**Consultation Response from KC,
Lead Local Flood Authority**

2023/92966 Land to the rear of, 271, Cliffe Lane, Gomersal, Cleckheaton, BD19 4SB

Demolition of existing dwelling and erection of 87 dwellings including formation of a new access from Cliffe Lane, landscaping, public open space and all associated infrastructure and engineering works

Date Responded: 14th November 2023

CLIENT	QUARTERS GOMERSAL
PROJECT	CLIFFE LANE, GOMERSAL
TITLE	SITE PLAN LAYOUT
DRAWING NO.	1694-101
REVISION	F
SCALE	1:500 @ A1
DATE	01.23
DRAWN BY	BC
CHECKED BY	-

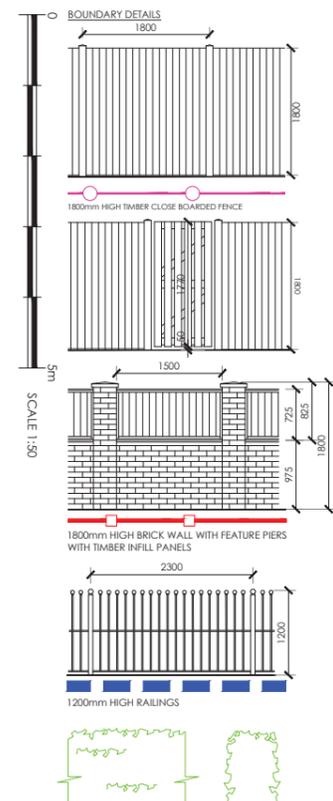
The LLFA rules out the use of infiltration techniques to dispose of surface water. However, some permeable paving is shown on submitted plans for certain driveways. It must be clearly demonstrated that these areas contribute to attenuation calculations as 'impermeable areas'.

Flood routing arrows around plot 1 on the drainage submission could be misleading. Engineering layouts show a low spot in this area. More detailed plans showing how flood routing from this point will be managed is required.

Boundary treatments around plot 10 need to be confirmed to clearly demonstrate free movement of overland flows in this area.

The low spot around plots 70-71 needs a more detailed presentation. As a main flood route, the design of a retaining wall blocking this route needs further consideration.
